2000-3 Arapaho Road
Extension - 1998

January 22, 1999

Re: Arapaho Road at Midway Road

EXHIBIT 'D'
ENHANCED PHOTOGRAPH-
MIDWAY OVERPASS

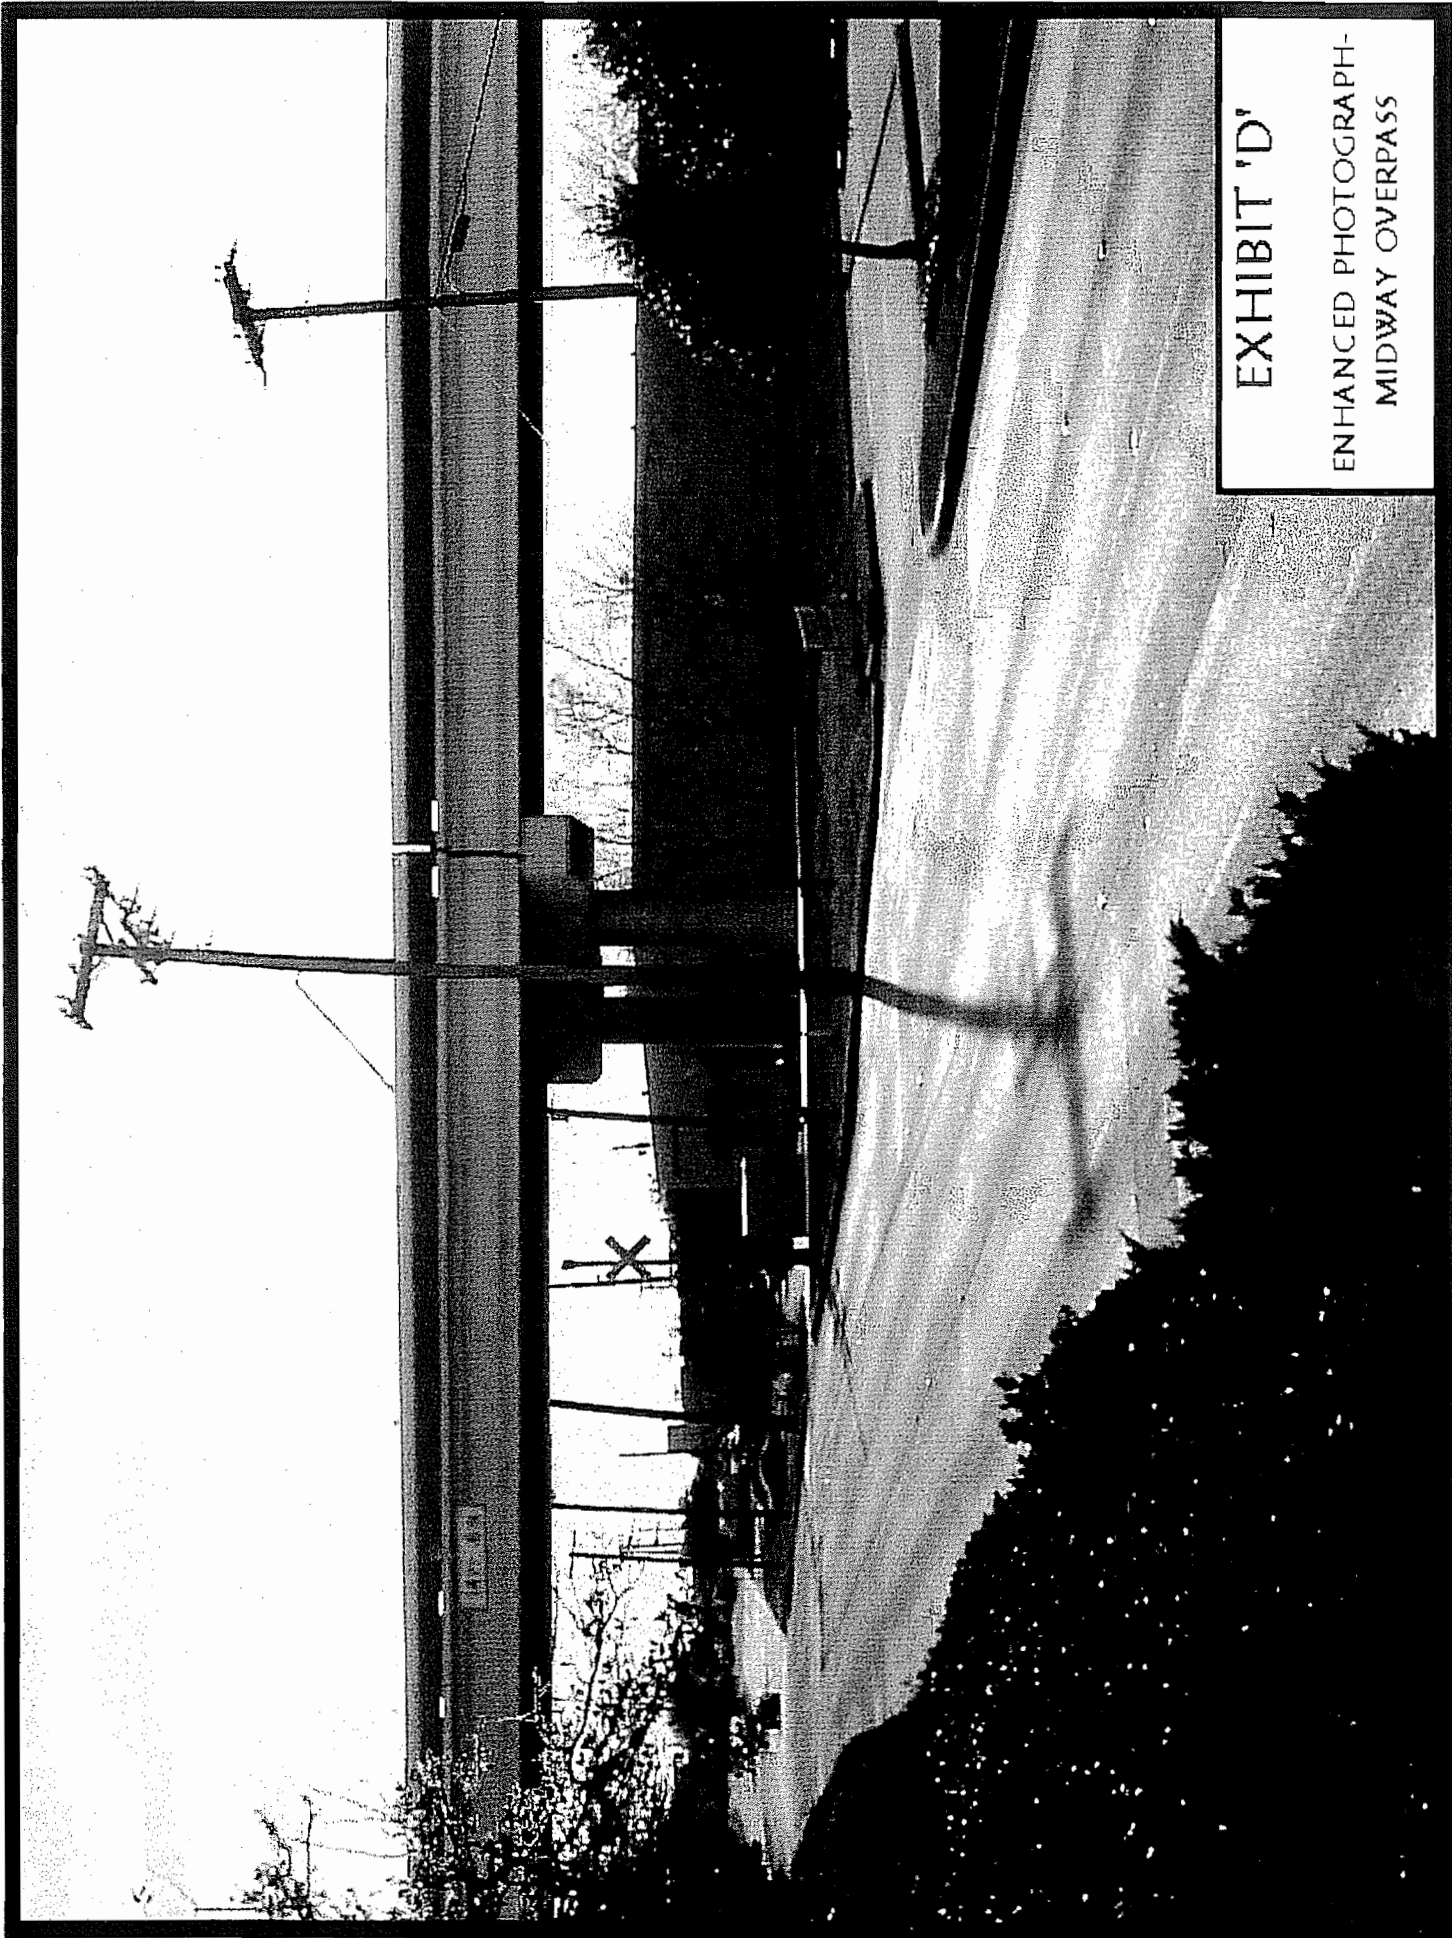
However, the configuration recommended is an overpass rising approximately 25' above the elevation of the Midway roadway, supported by an embankment. With all respect to Ron Whitehead and John Baumgartner; the tenants, manager and owners of 15101 Midway object to an Arapaho Road overpass at Midway Road.

- The bridge and embankment will eliminate visibility of 15101 Midway from the north. The east half of the property is the flagship store of Charter Furniture, a retailer with most of its trade area and business north of this location, heavily relying on visibility from the north.
- The bridge and embankment will loom over 15101 Midway, casting it in an inferior perspective to visitors. This and other properties west of Midway have floor elevations well below the Midway roadbed.
- The overpass scenario costs approximately \$4 million more than an at-grade intersection.
- The lack of interchange with Midway Road lessens the tendency of travelers to choose to stop at merchants, restaurants and hotels in the immediate vicinity, favoring communities on either side of Addison.

If, after reviewing the facts, the Council decides to use an overpass, we respectfully request an opportunity to work with the staff during the planning stage to arrive at a minimally intrusive, architecturally pleasing design. This may mitigate our concerns. We would also want to live up our signage and building image to enhance visibility, of course within the framework of the Town's ordinances.
